Subject: 1 Orchard Way, Fontwell - WA/91/21/DOC

It should be noted, that the applicant (WA/91/21/DOC) has not provided the planning department with a Method Statement, as required by condition 15 (WA/18/19/PL) and so it is understandably set for refusal in current form.

I have considered the drawing 'UNIT ONE + TWO drainage layout', dwg. nb:17101+305A. The intended route of utility apparatus beyond the building footprints involves further RPA incursion, although it appears to be logical and ought to be achievable without recourse to specialist engineering methods, given what we have observed from earlier trial hole excavation and the adoption of a suitably morphed (polygon) RPA. The quality of ground protection installation recorded pre-commencement further encourages my support for this proposal.

UNIT ONE + TWO

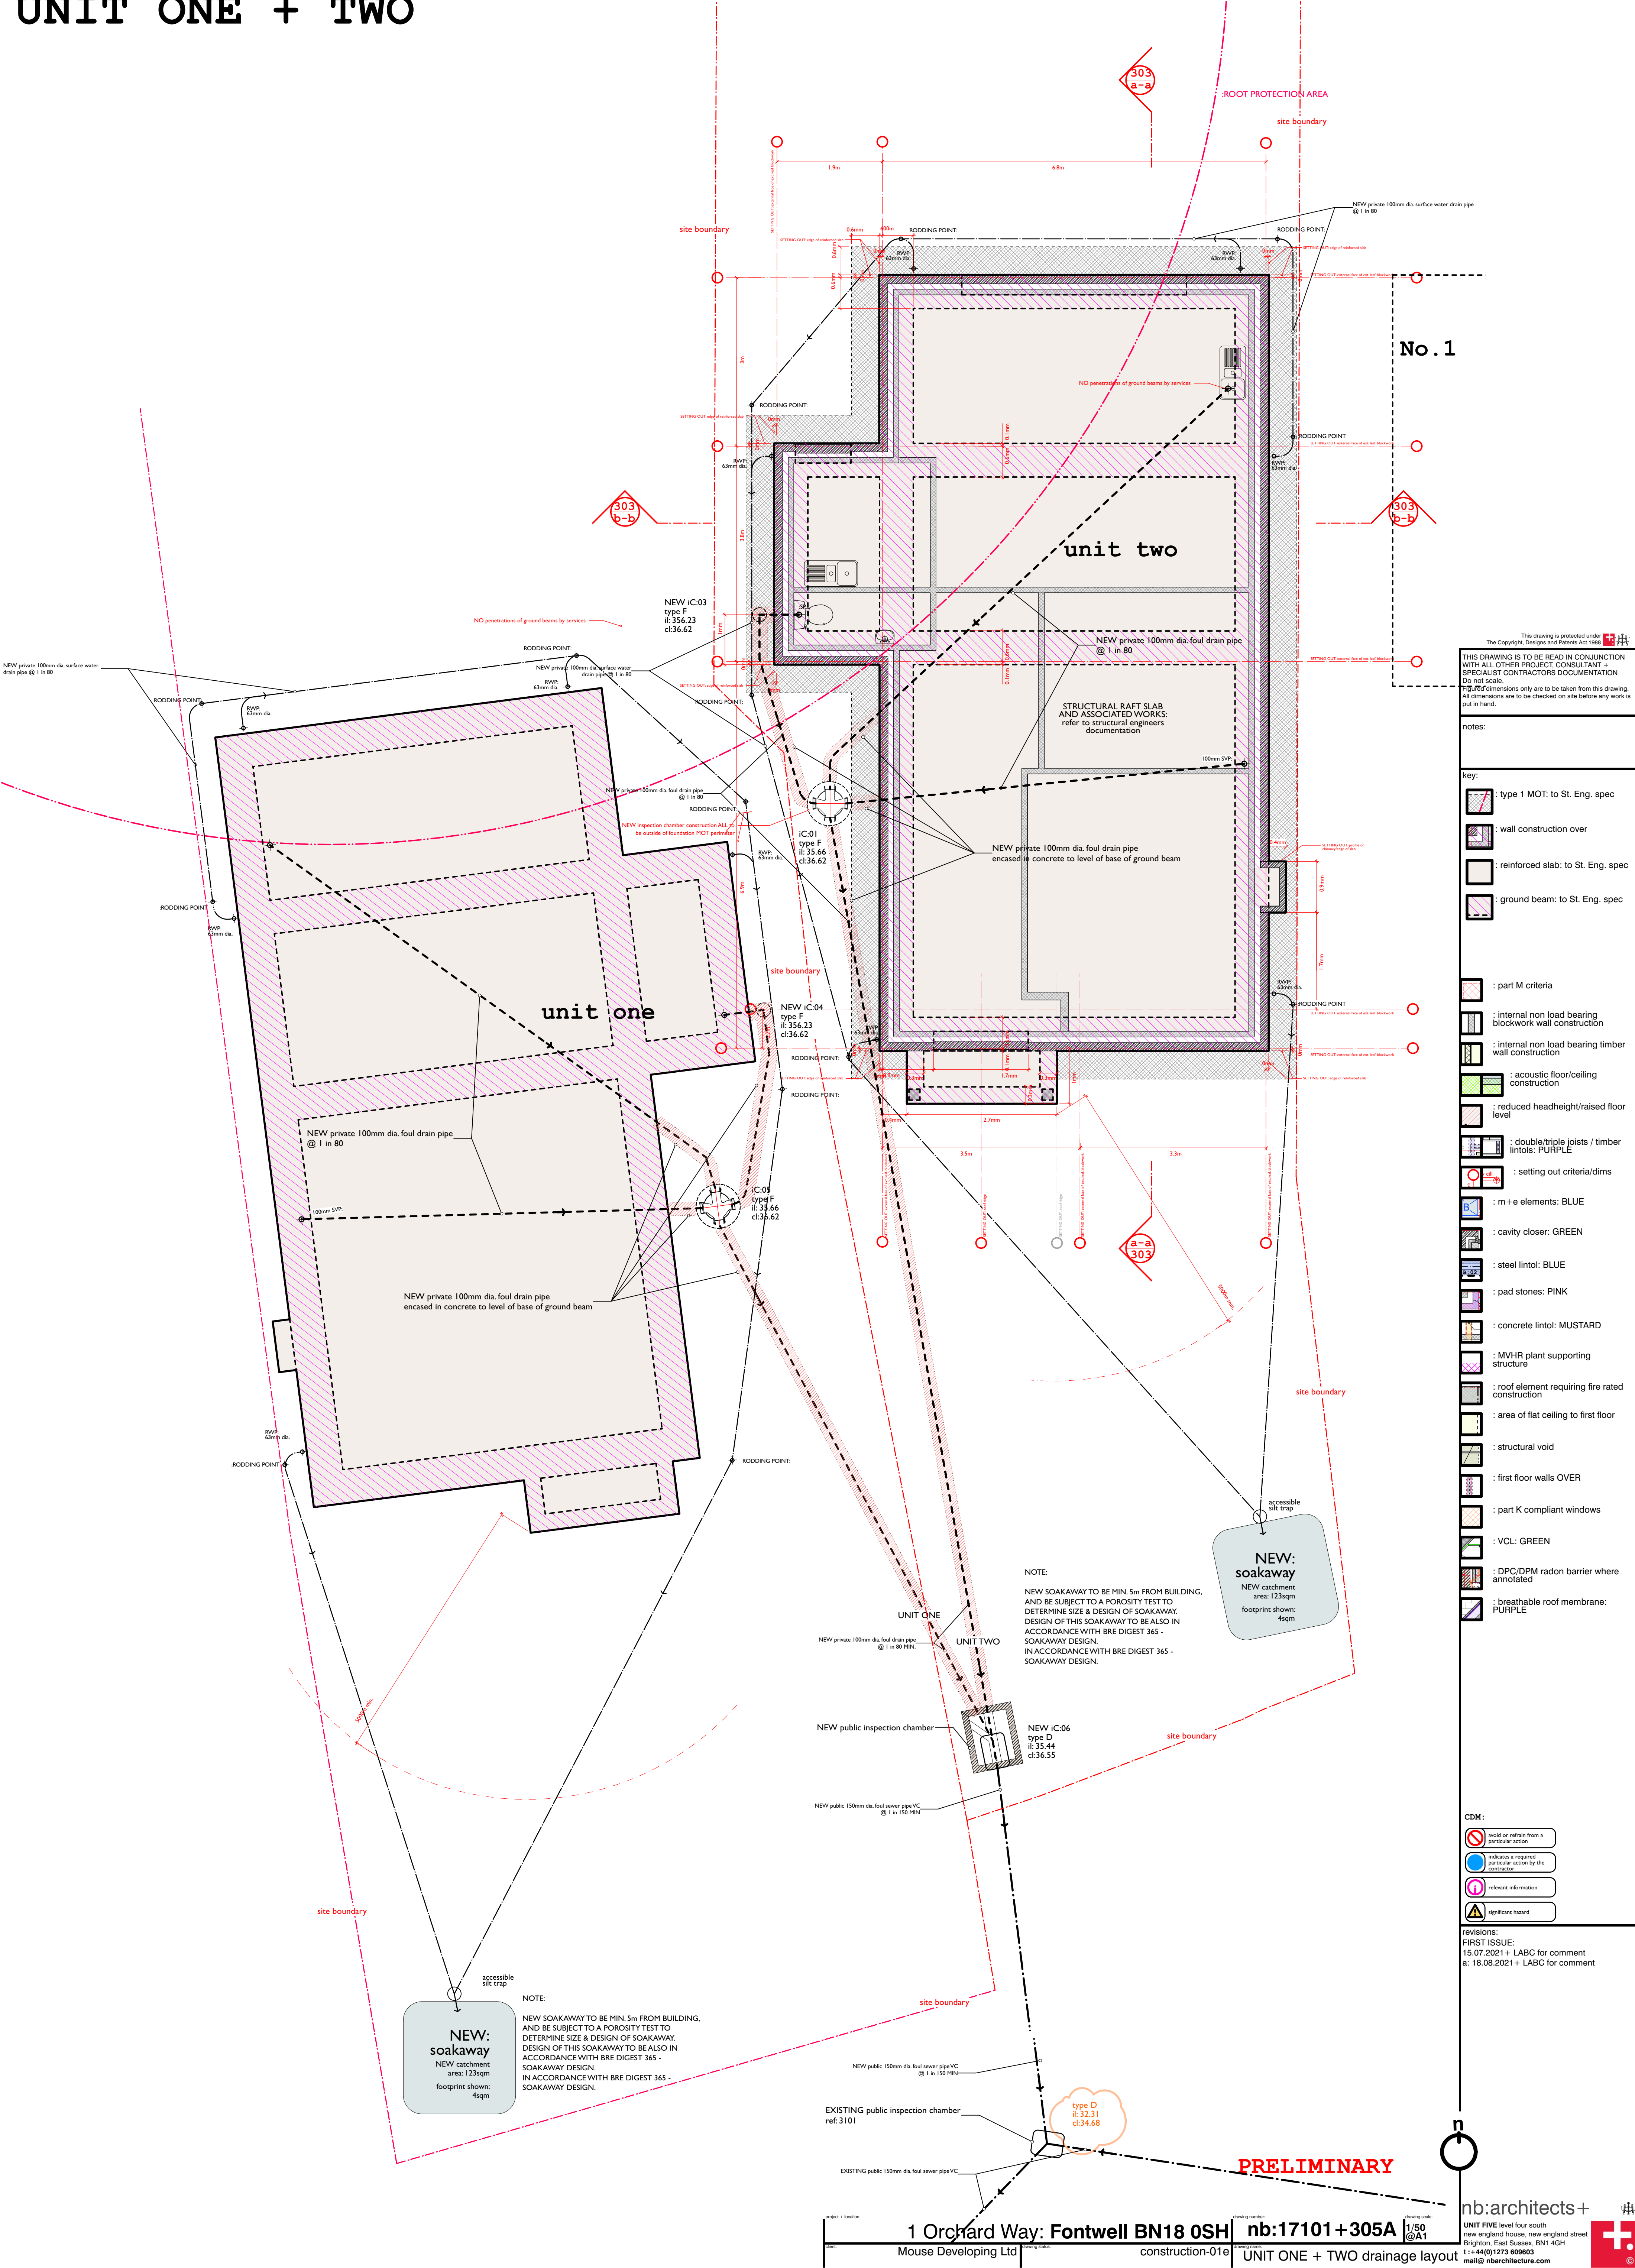
I assume traditional open excavations are to be dug for the installation of all pipework within the Root Protection Area (RPA) of T1 Oak. If so, that work ought to be undertaken in compliance with Guidelines set out in NJUG Volume 4 – Guidelines For The Planning, Installation And Maintenance Of Utility Apparatus In Proximity To Trees and ideally should be supervised by the project arboriculturist. This important principle is not referred to explicitly in the current approved Arboricultural Method Statement (AMS) as it was assumed all service connections would be from road side, therefore a mini-Method Statement (mMS) is now required and to be submitted for LPA approval prior to those works commencing.

The mMS should confirm the width and depth of the excavations and maximum amount of unprotected ground tree-side of the excavation to facilitate same.

You should either directly supervise all excavation within the RPA (or ensure your client submits a report for your endorsement) and provide the LPA with confirmation of compliance with those Guidelines, to be supported with photographic evidence.

Please provide confirmation that ground protection (as approved and installed) remains intact and 'fit for purpose' and is to be modified only to allow minimal clearance tree-side of the excavation. Any plant operating within the RPA may demand an enhancement of the ground protection, to remain 'fit for purpose' – (see BS5837:2012, para. 6.2.3.3).
